Rezoning Transportation Analysis

Petition Number: 2021-168

Date	Description
11-19-2021	First Review (KP)

**RZ1.0**

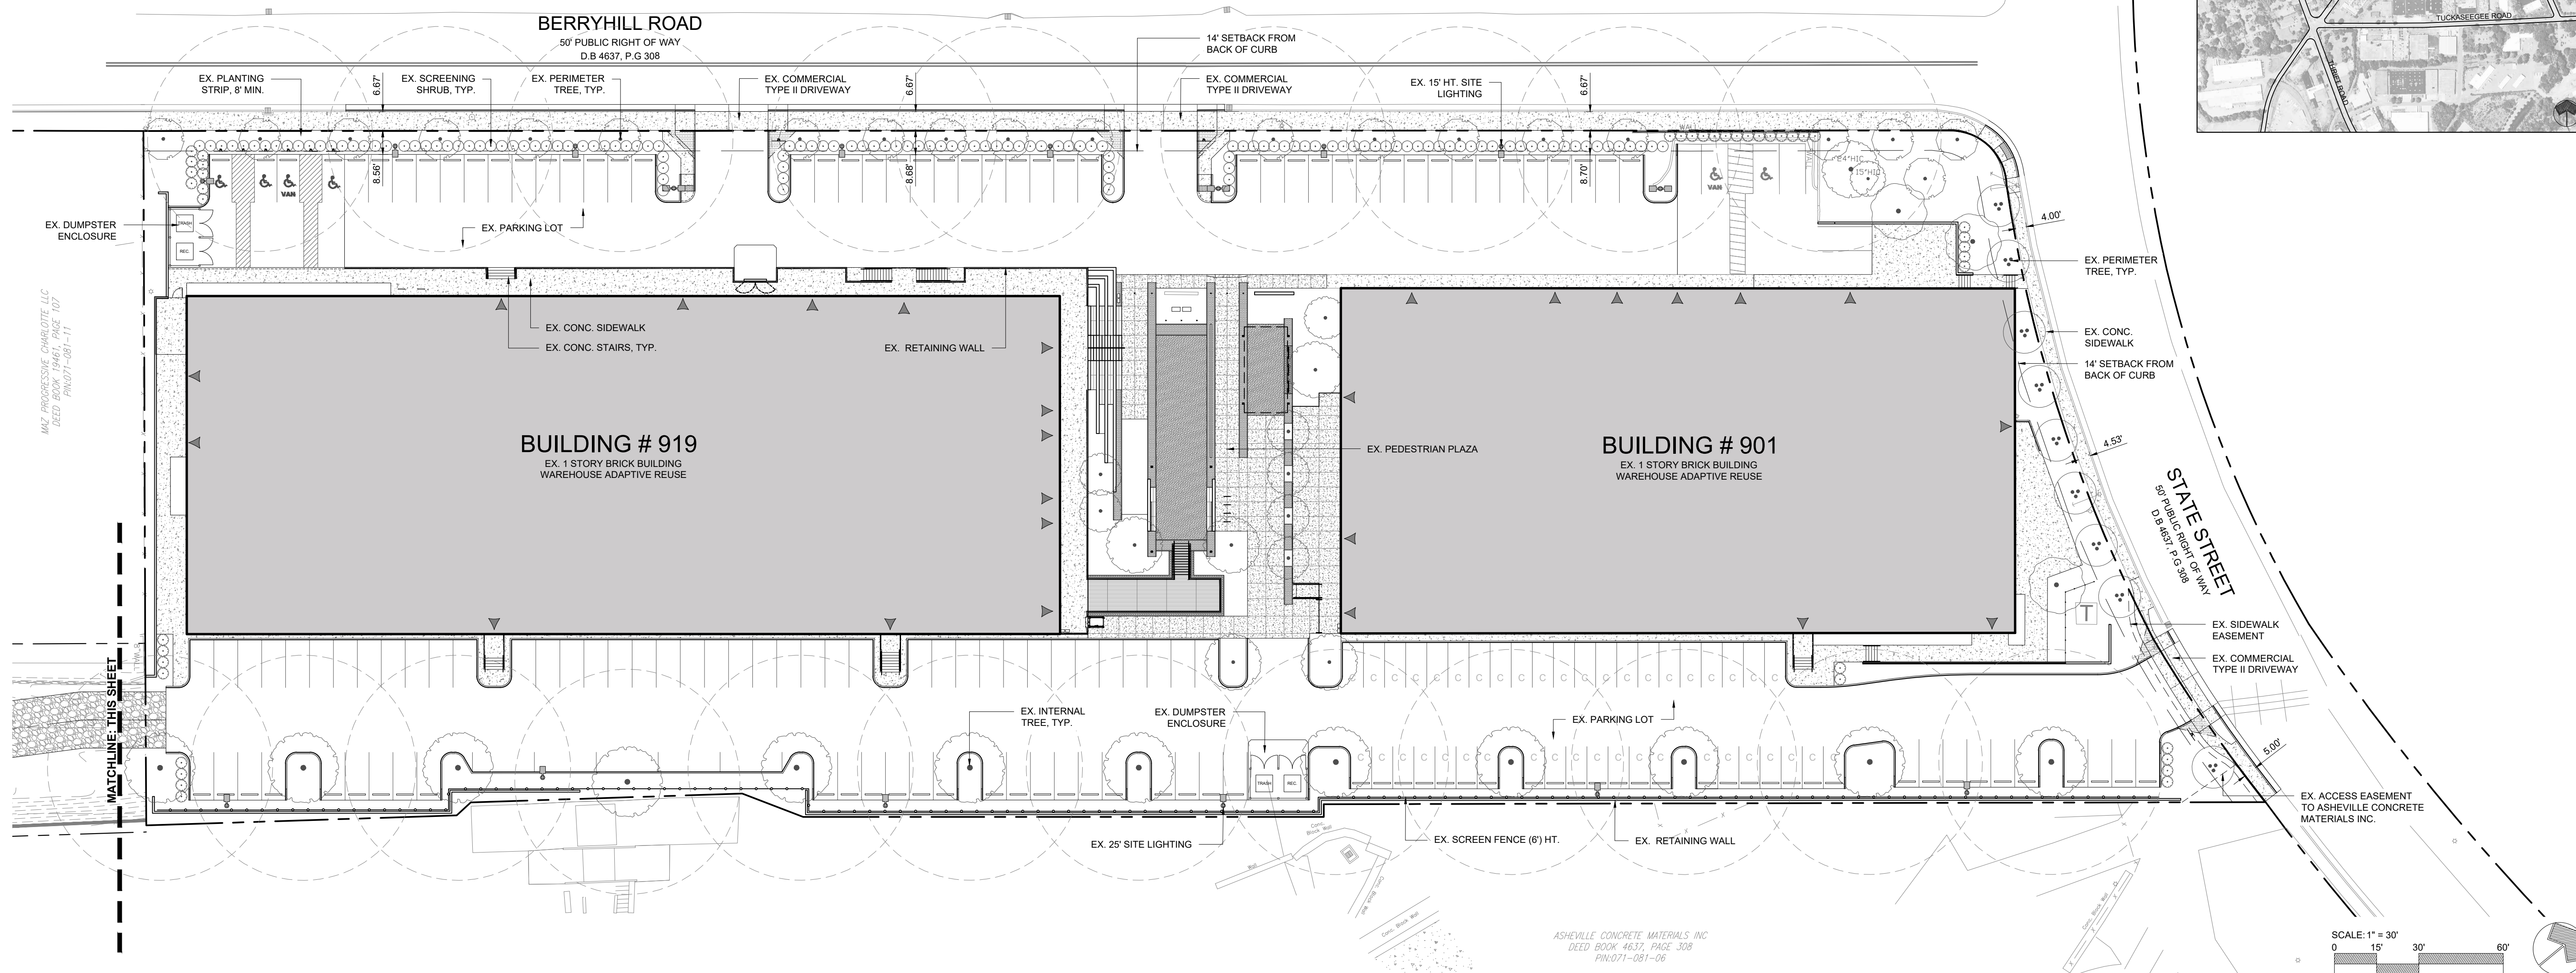
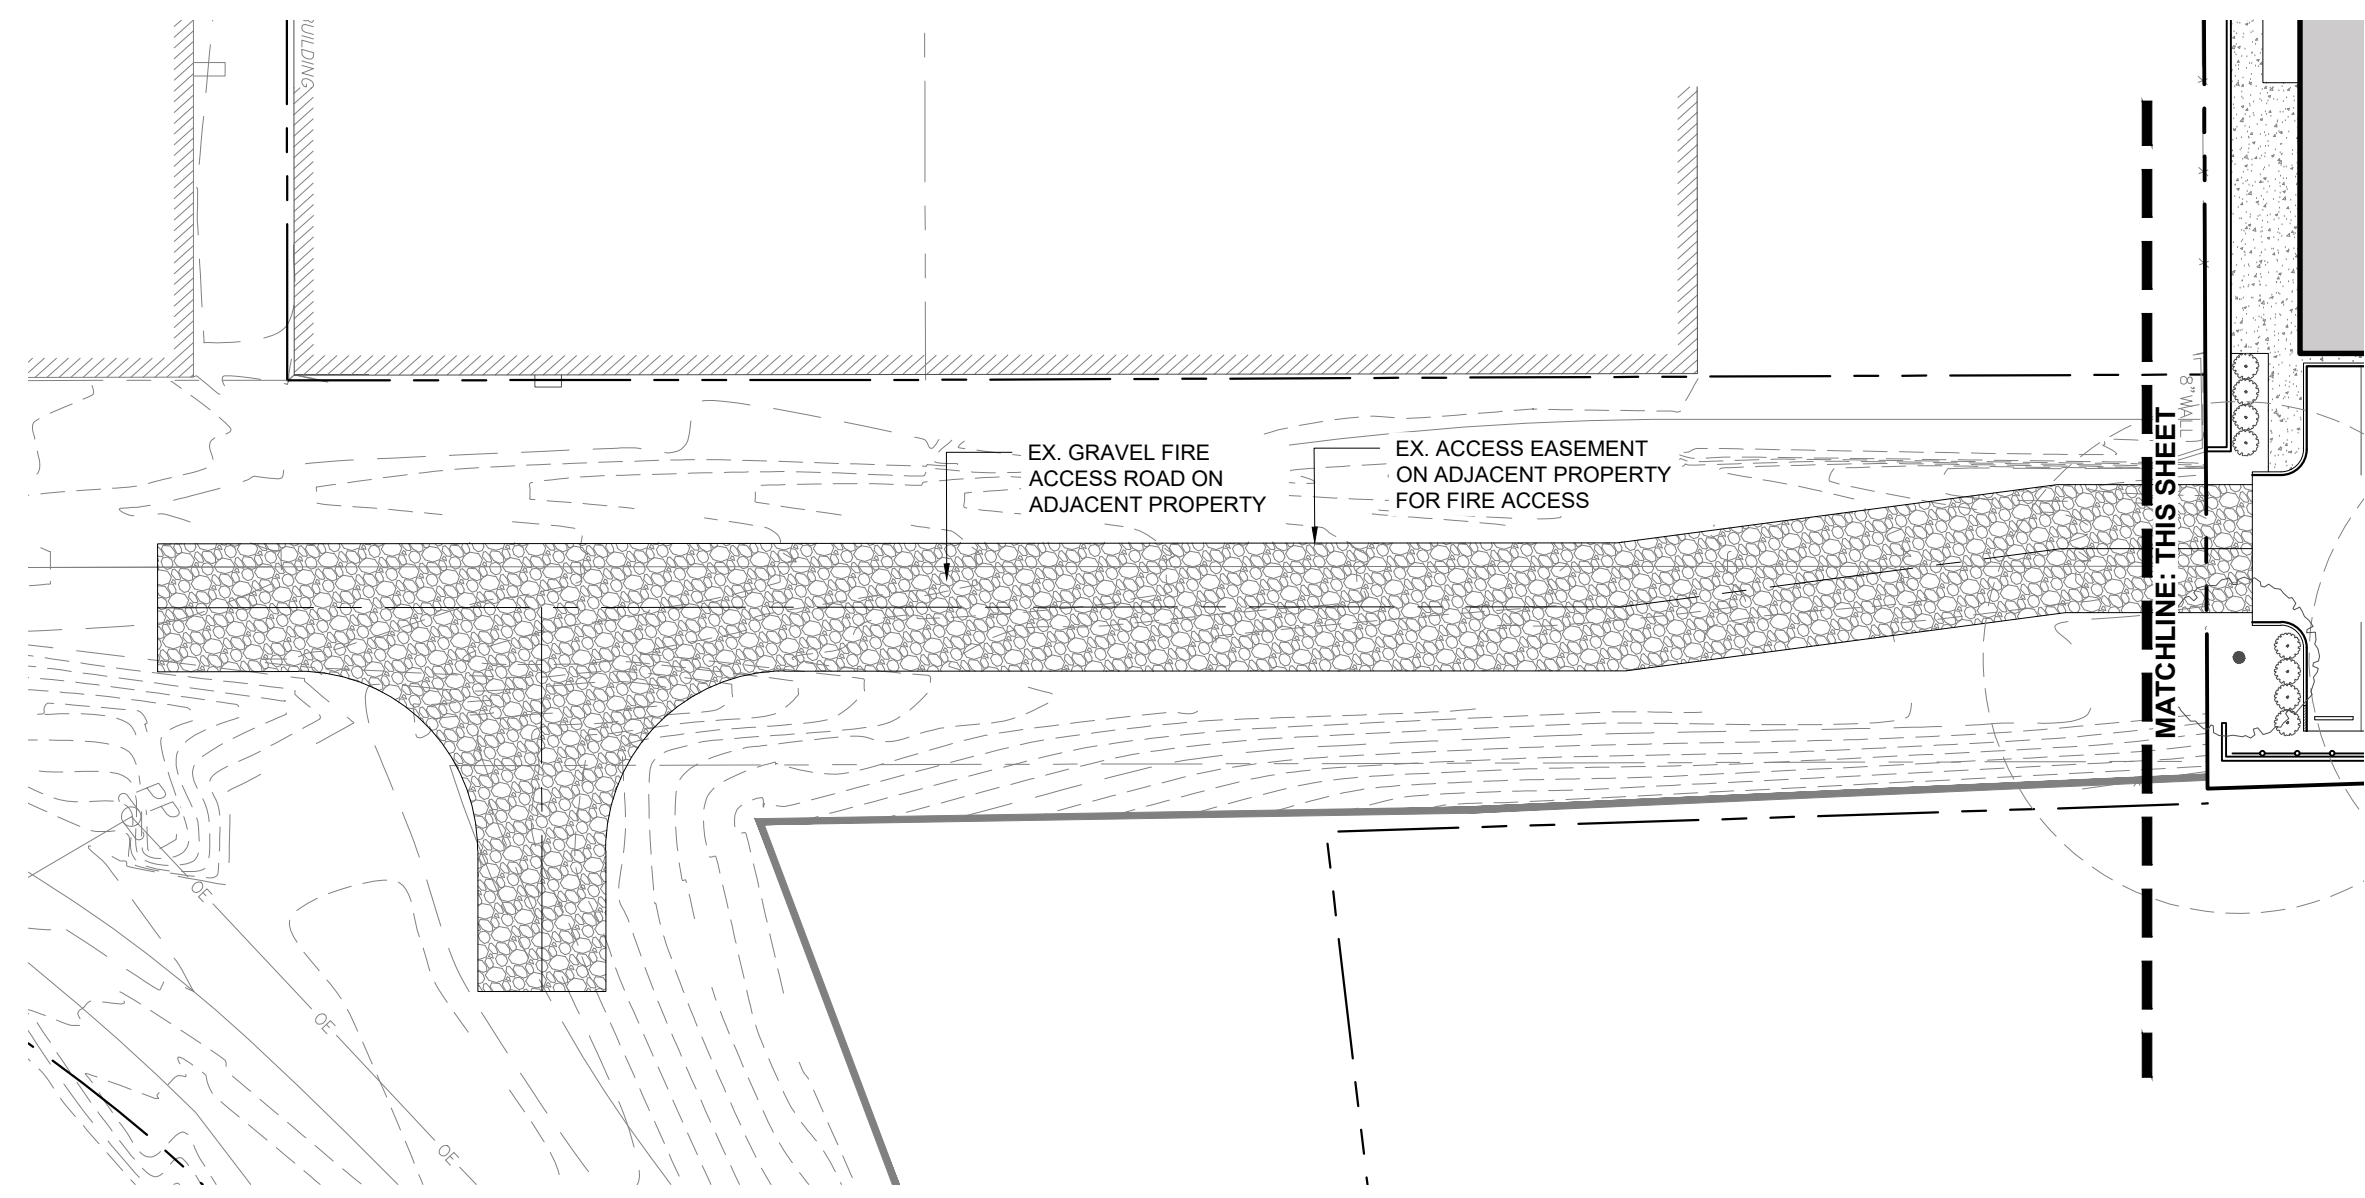
1. **Curb line:** The proposed zoning district has a setback measured from back of the existing or proposed future curb line.
 - a. **Berryhill Road:** In accordance with CLDSM U-07 (Local Collector Street), the future location of back-of-curb and gutter will be 17.5-feet from the existing centerline, however, due to site constraints, the curb and gutter may remain in it's existing location.
 - b. **State Street:** In accordance with CLDSM U-07 (Local Collector Street), the future location of back-of-curb and gutter will be 17.5-feet from the existing centerline, however, due to site constraints, the curb and gutter may remain in it's existing location.

Label and dimension the existing and future back-of-curb and gutter from the existing centerline of each road.

- a. **Berryhill Road:** Revise the site plan and conditional notes to commit to dedicated 36-feet of right-of-way from the existing road centerline, in accordance with CLDSM U-07 (Local Collector Street).
- b. **State Street:** Revise the site plan and conditional notes to commit to dedicated 36-feet of right-of-way from the existing road centerline, in accordance with CLDSM U-07 (Local Collector Street).

The site plan shall label and dimension the dedicated right-of-way from the existing centerline of each road.

4. Revise site plan and conditional note(s) to commit to construct an 8-foot planting strip, and 6-foot sidewalk along the site's frontage of Berryhill Road and State Street. The planting strip and sidewalk shall be oriented where the planting strip is located in between the sidewalk and back-of-curb. The site plan shall label and dimension both items from the back of curb and gutter.

- 5. Revise site plan and conditional note(s) to commit to construct a minimum 8-foot sidewalk along the site's frontage of State Street and Berryhill Road where the sidewalk is located at the back-of-curb. Additionally, the sidewalk width will be maximized where the existing building(s) or other site constraints inhibit an 8-foot sidewalk. These location(s) and sidewalk width(s) will be subject to approval by CDOT during permitting. Lastly, remove conditional note 2.b.

6. Revise the site plan and conditional notes by showing the driveway location associated with Asheville Concrete Materials, PID#07108106, as approved in permitting set LDC-2021-00081. This driveway shall not be affected by any improvements associated with this site.

7. Revise the site plan and conditional notes by committing to connect the 8-foot sidewalk, located at the back-of-curb along the site's frontage of State Street, into the driveway associated with Asheville Concrete Materials, PID#07108106, as approved in permitting set LDC-2021-00081.

8. Revise the site plan and conditional notes by committing to construct two ADA curb ramps at the corner of Berryhill Road and State Street, in accordance with CLDSM.
